**KIRKLEES METROPOLITAN COUNCIL
INVESTMENT & REGENERATION SERVICE**

Reference No:	2025/62/90377/E
Site Address:	9, Dunbottle Lane, Mirfield, WF14 9HY
Description:	Erection of two storey side extension
Recommending Officer:	Elenya Jackson

DECISION – CONDITIONAL FULL PERMISSION

OFFICER REPORT

Dwg. no: 4616.P.1

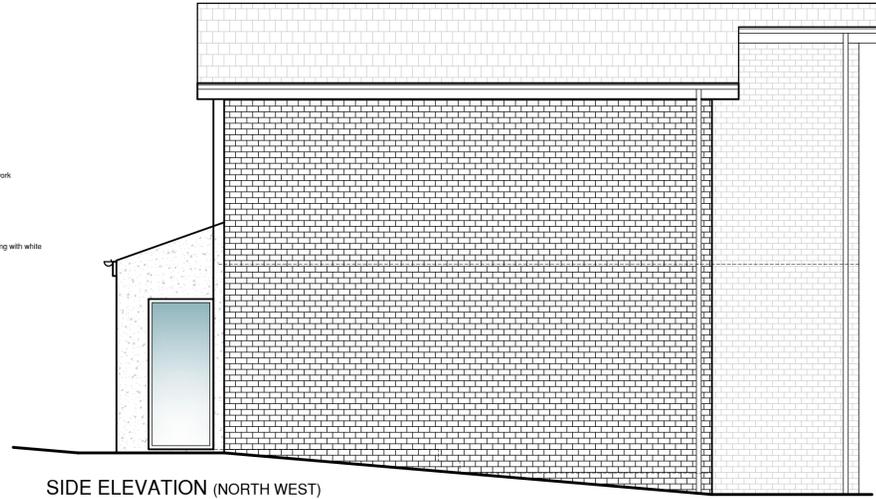
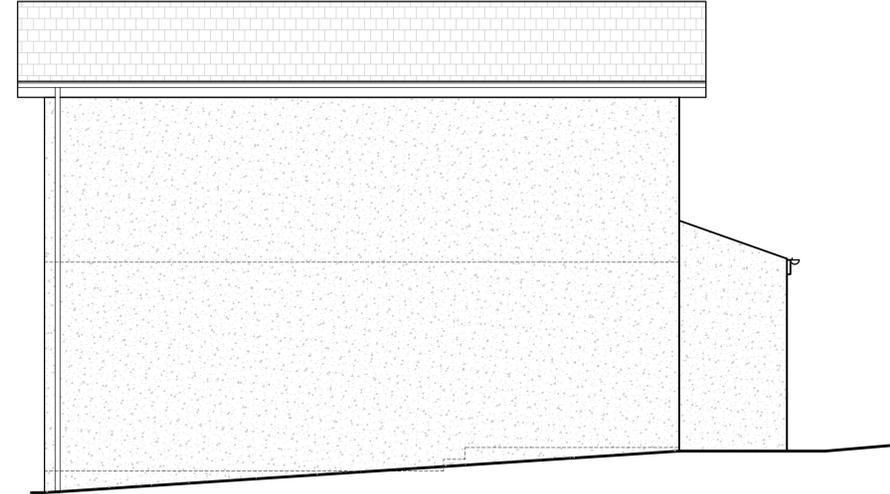
The two storey side extension, which includes a first floor over the existing garage, would extend 3.6m beyond the side elevation of the host dwelling, have a depth at first floor of 8.9m, a maximum height of 5.9m and an eaves height matching the host dwelling. This would be in line with the front and rear of the dwelling.

As part of these works, there would also be works to the front of the dwelling. The alterations to the front would extend 1.5m beyond the principal elevation of the dwelling.

It is acknowledged that the proposal would not be set back from the front wall of the dwelling; however, officers consider that the proposal would largely occupy the same footprint as the existing garage, would be set down from the host dwelling which would aid its subservience, would retain spacing within the neighbouring property and be constructed out of materials matching the host dwelling with the exception of where the timber panels would be replaced with render. It is considered that the use of matching materials would aid the proposals assimilation with the host property and that elements of render would not result in the proposal appearing out of keeping with the surrounding area.

With regard to the alterations to the principal elevation, it is considered the porch would be limited in scale, constructed out materials matching the host dwelling and set back from the street scene and would therefore have an acceptable impact on the character of the host dwelling and surrounding area.

Overlooking: The proposal would not have any side facing windows at first floor level. The additional first floor window in the rear will not result in any greater overlooking or loss of privacy when considering the existing window relationship.

Overshadowing/loss of light/overbearing: No.7 features one side facing window which looks towards the application property. The proposed first floor extension would extend 3m closer to no.7 than the existing relationship;

however, it is considered that there would still be a reasonable gap retained between the properties, the proposal would not extend beyond the front or rear of the host dwelling and would be set down from the ridgeline. It is considered that these factors when coupled with the orientation of the properties would prevent any significant overshadowing/loss of light or overbearing.

Overlooking: The proposal would feature one side facing window relating to the porch area. It is considered this would be in-line with the front garden of no.11 and no significant issues would be raised regarding overlooking. The additional first floor window in the rear will not result in any greater overlooking or loss of privacy to the neighbour when considering the existing window relationships.

Overshadowing/loss of light/overbearing: It is considered that the two storey side extension would be largely screened by the host dwelling and the alterations to the front are not of significant scale to raise any concerns regarding overshadowing/loss of light or overbearing.
